August 7, 2019

Ms. Kym Dicome, Chairwoman
Development Review Board
Planning Department
City of Albuquerque
PO Box 1293
Albuquerque, New Mexico 87102

Reference: DRB Project #PR-2019-002496
Site Plan – Alameda Luxury Apartments

1 Site Plan - East
1" = 20'-0"

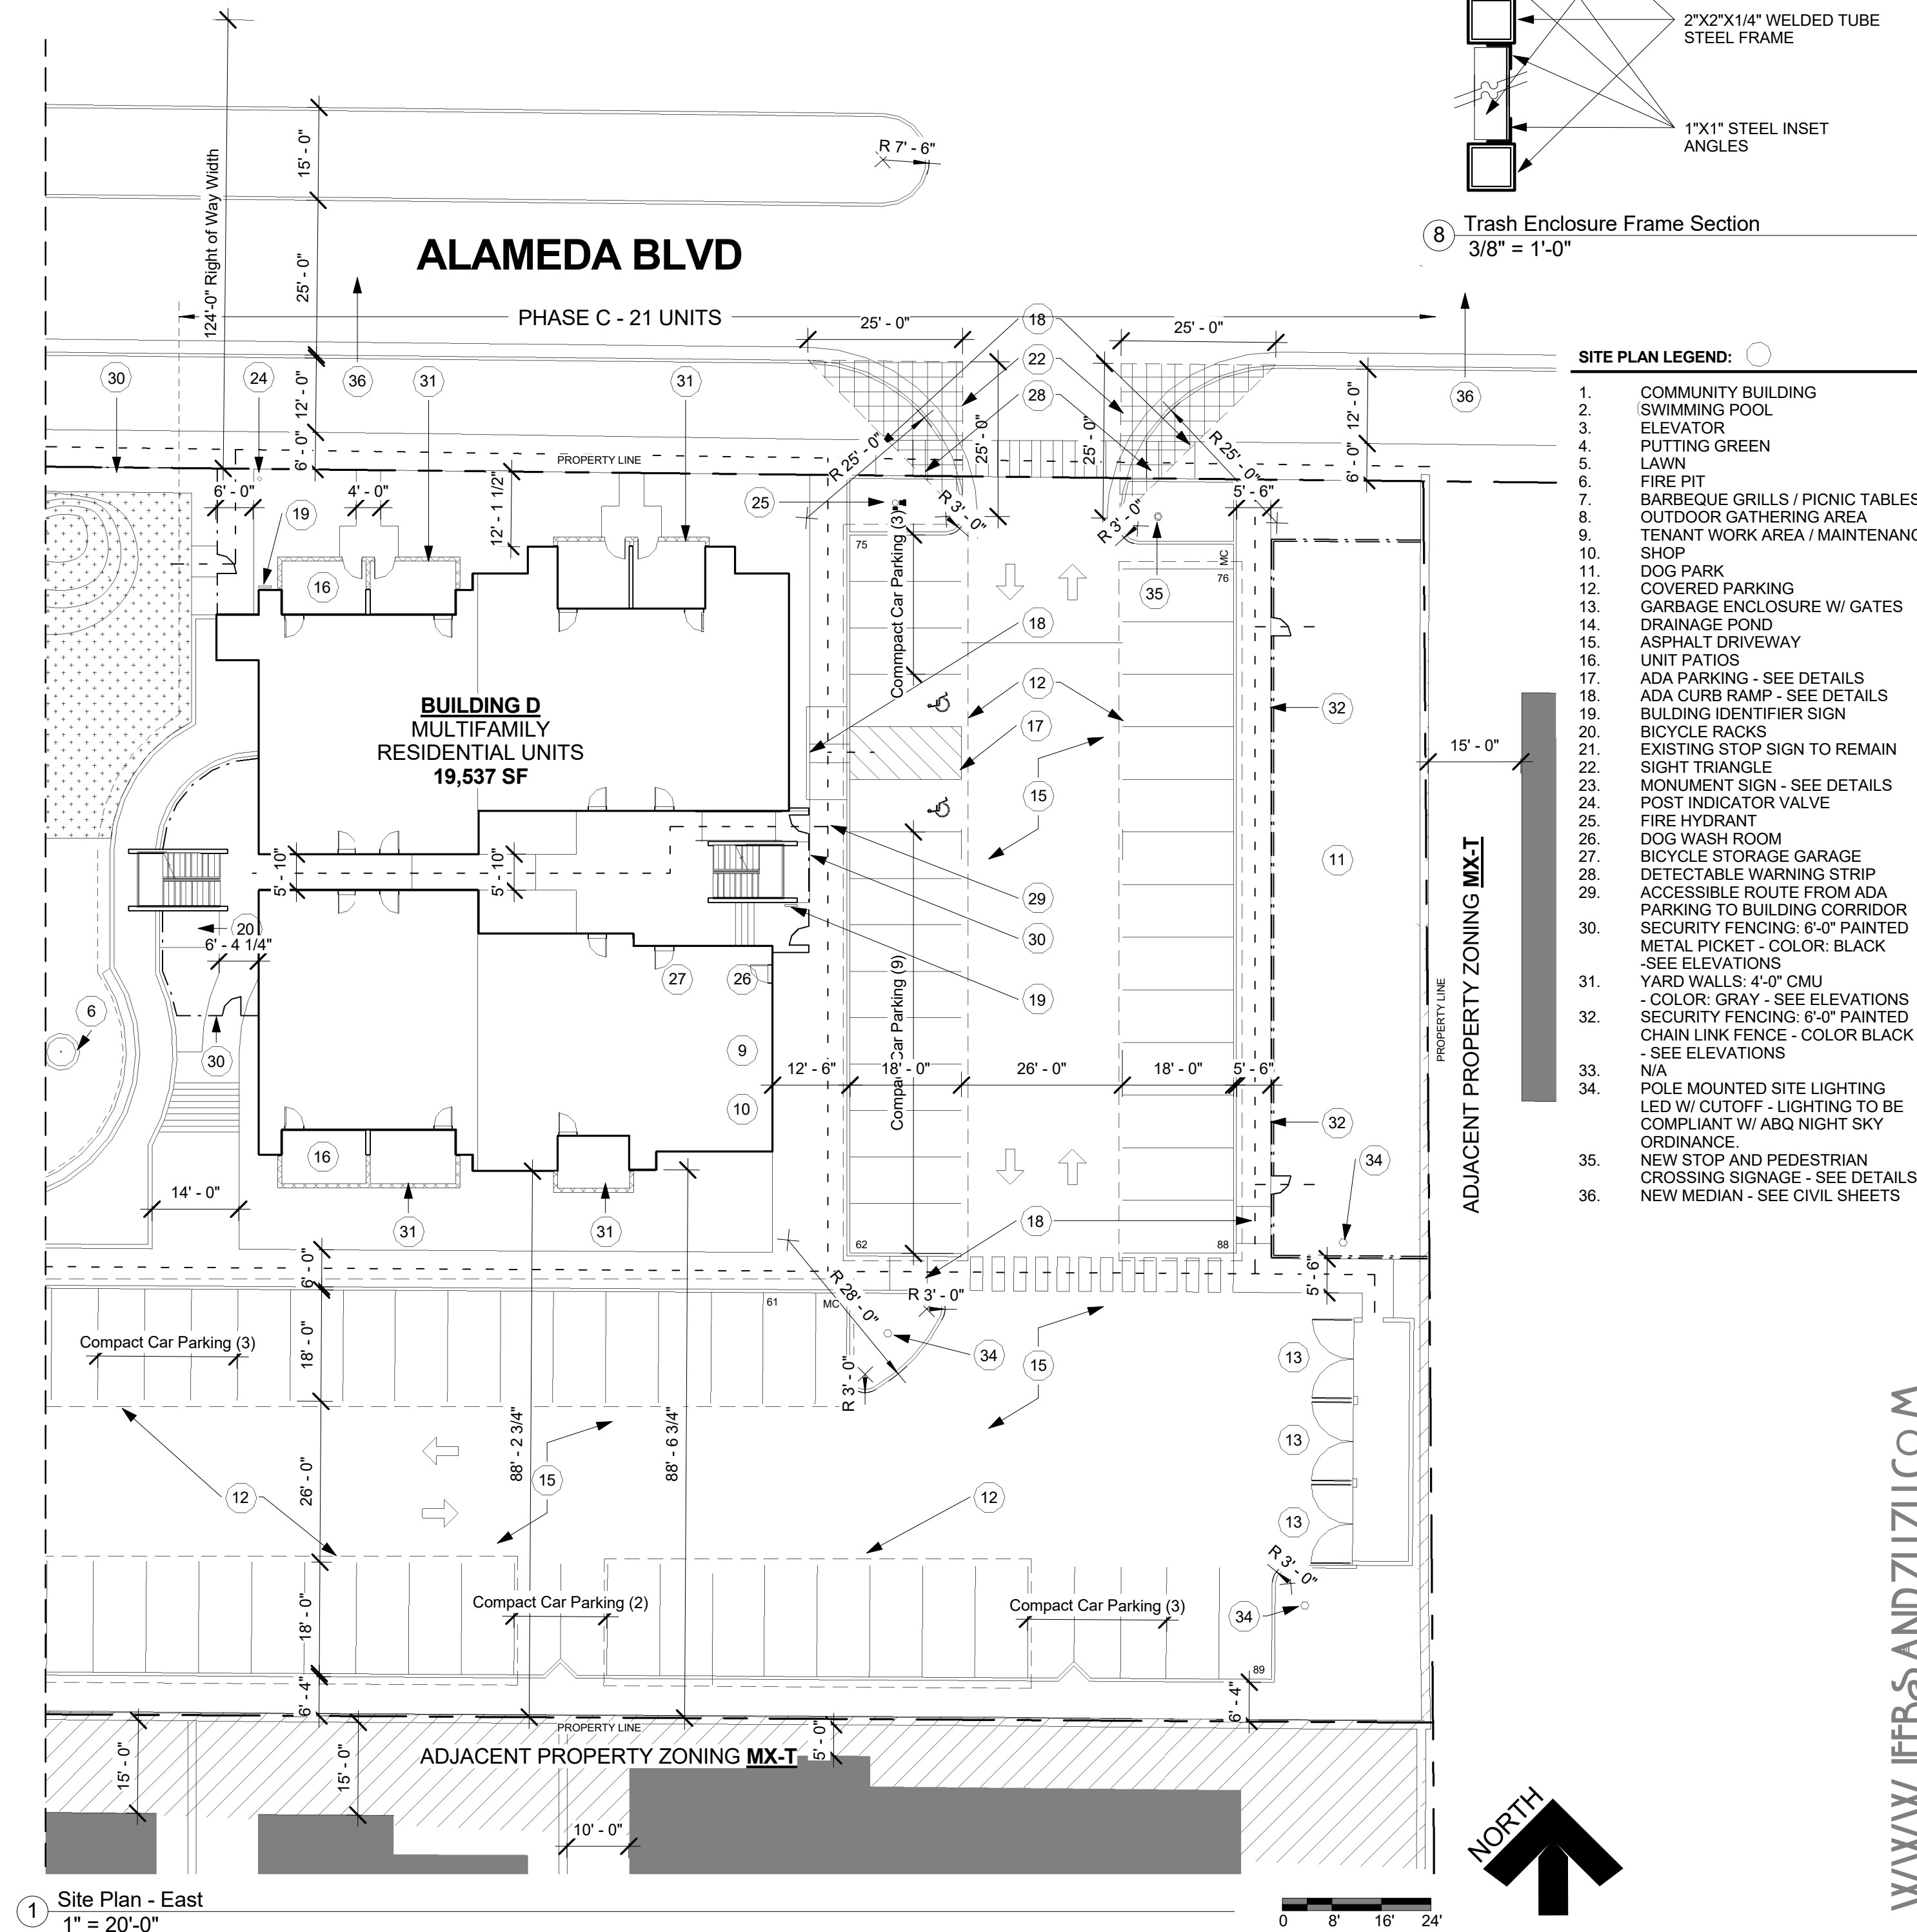
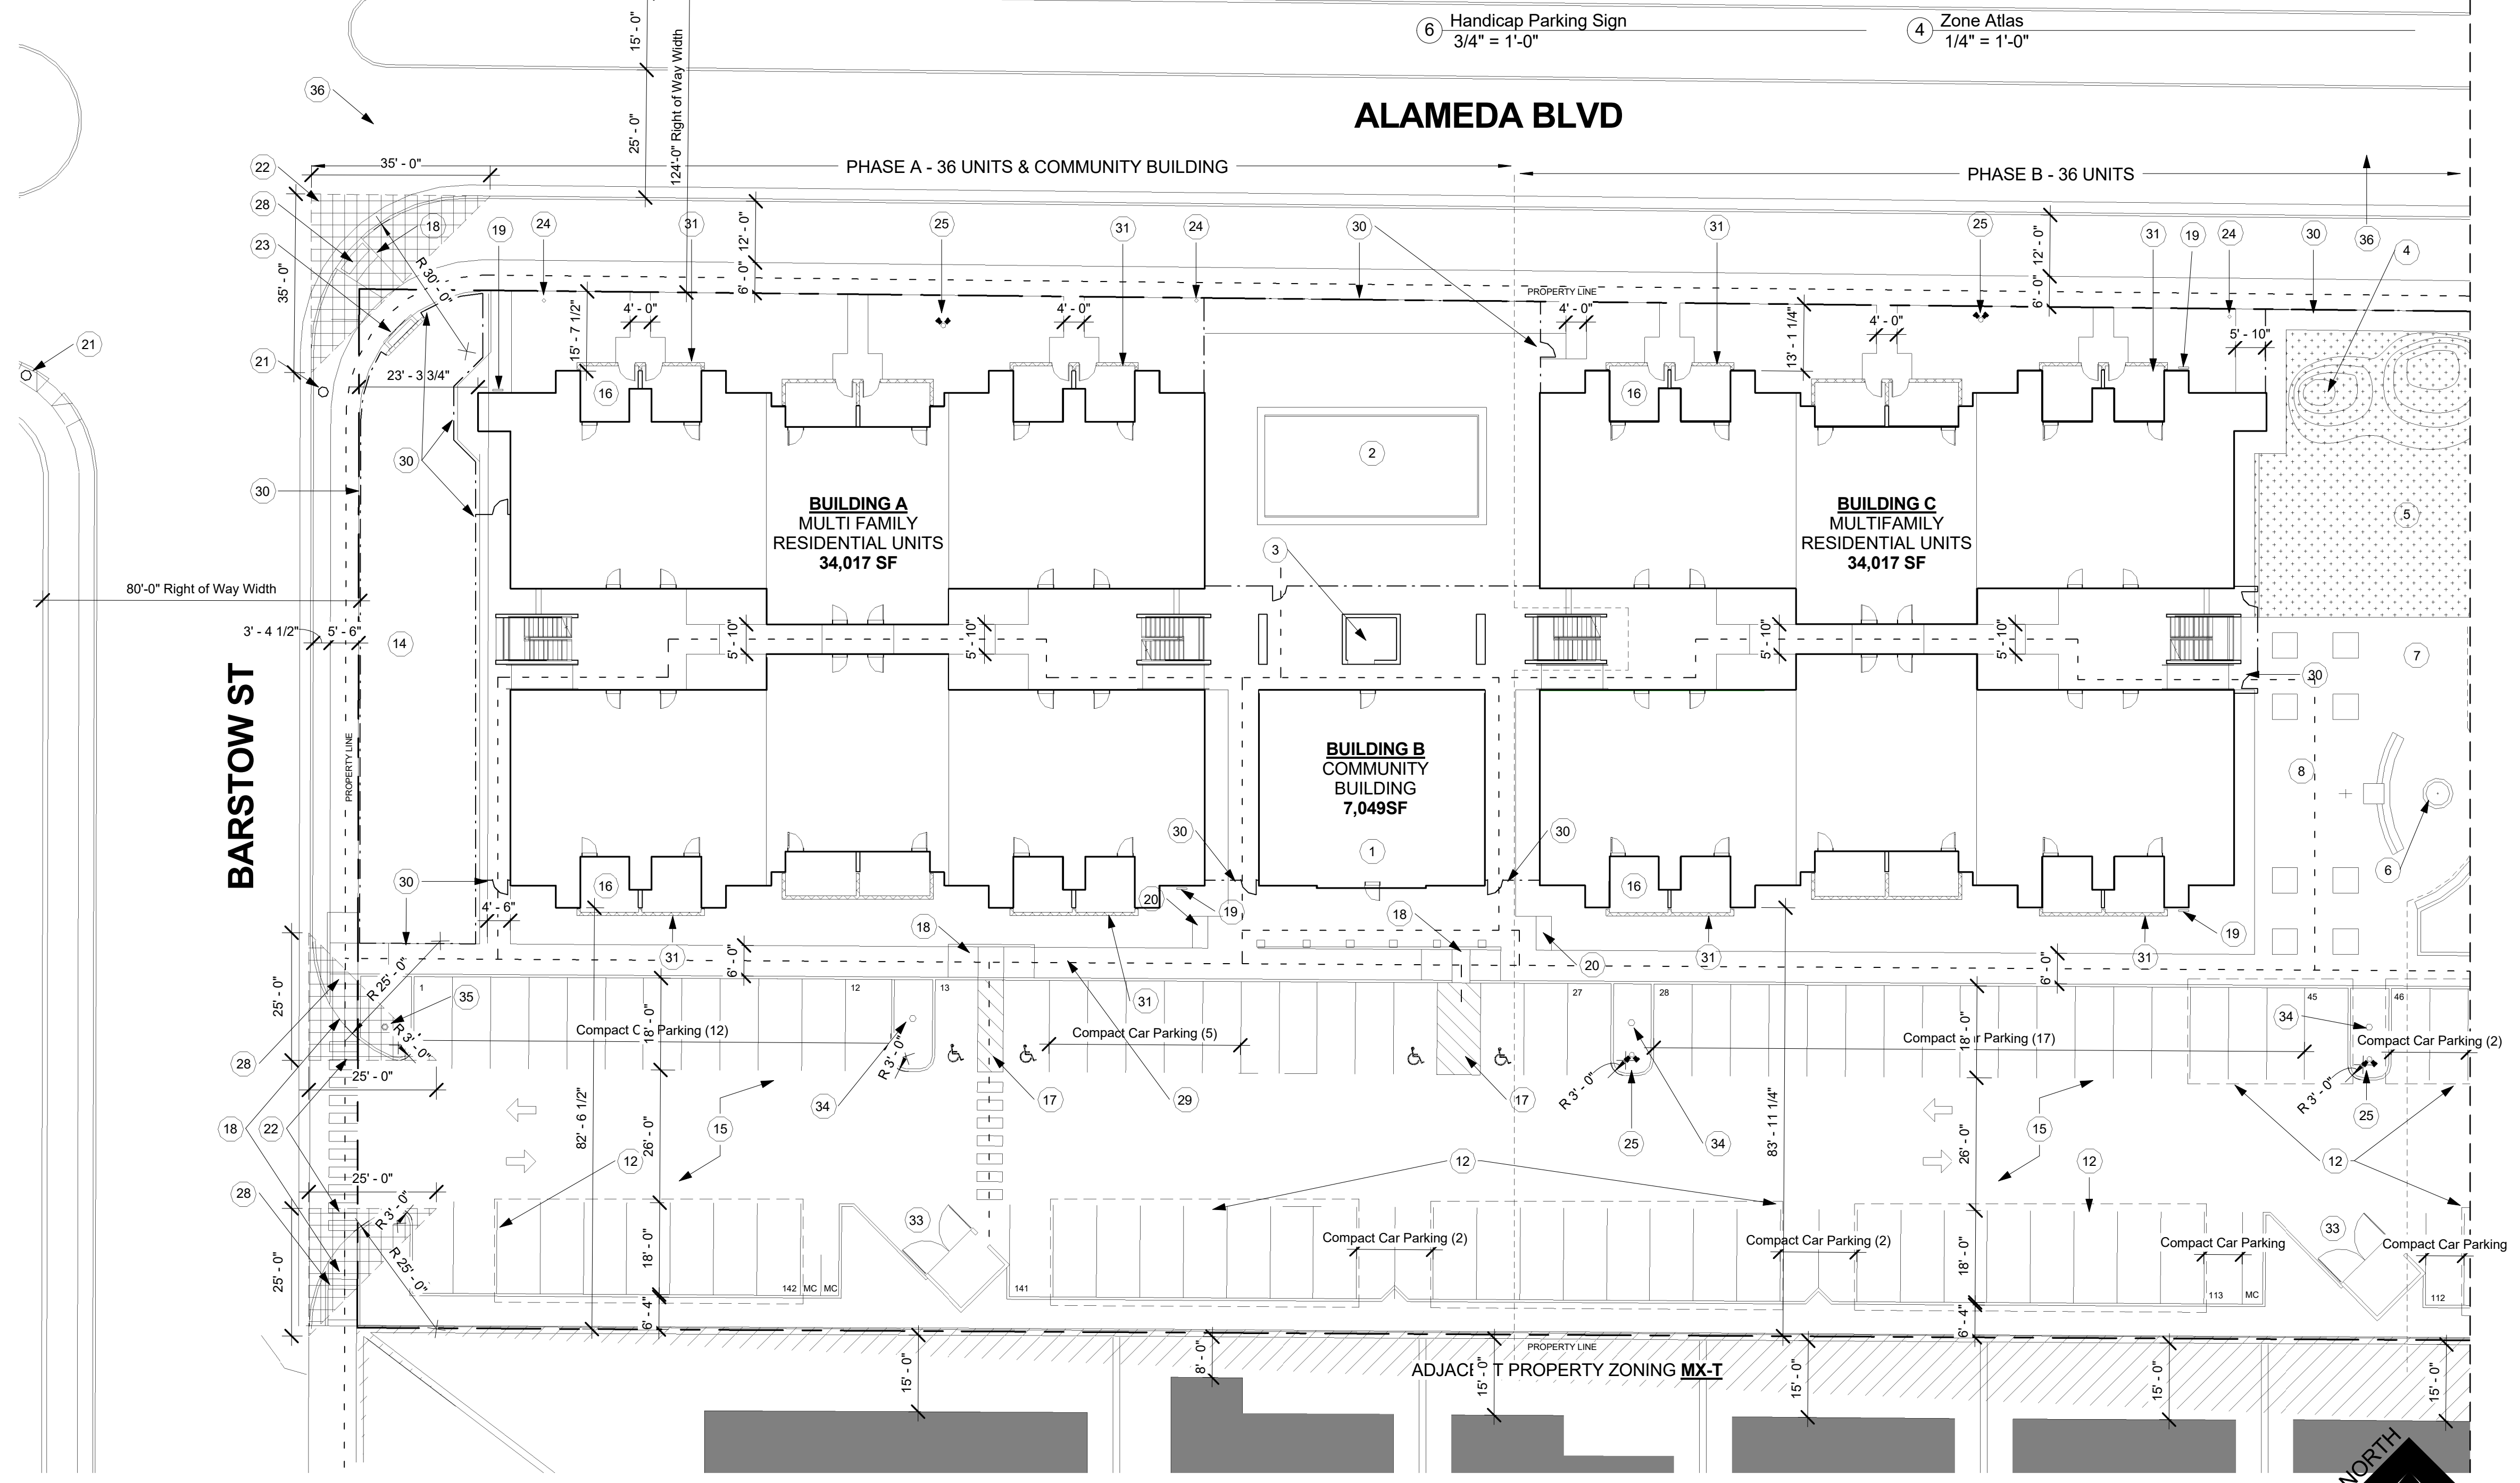
The proposed development is not sufficiently buffered from Tierra Morena, the adjoining single-family residential property to the south. Adjacent to the rear yard walls along its north side, the apartment parking area contains 125 spaces that run virtually the entire length of the property. This parking area provides most of the spaces required; it is 62' wide by more than 600' long or at least 37,200 sf in area. It also contains two large dumpsters serving the entire development. An area this large will have major environmental impact on adjoining homes in the form of noise, carbon monoxide, and the heat island effect.

The Vineyard Sector Plan had specific requirements for buffering. It anticipated that the site in question would be developed as a commercial site per its zoning with a drive area running behind buildings. As such, the first requirement for landscape buffering, defined on page 60 of the Plan, specifies "The Standard buffer landscaping shall be a landscaping strip at least twenty feet wide, located along the residential/non-residential boundary. The buffer shall include a screen wall or continuous hedge at the property line at least 6 feet in height." Another provision was that the buffer would "consist of primarily trees and shrubs which grow to a height of at least fifteen feet within five years of planting. The trees and shrubs in the landscaping strip shall form largely an opaque screen." The site plan under review shows a landscape strip 6'-4" wide with three tree species. This buffer is substantially narrower than specified and is not reasonable or adequate given prior requirements.
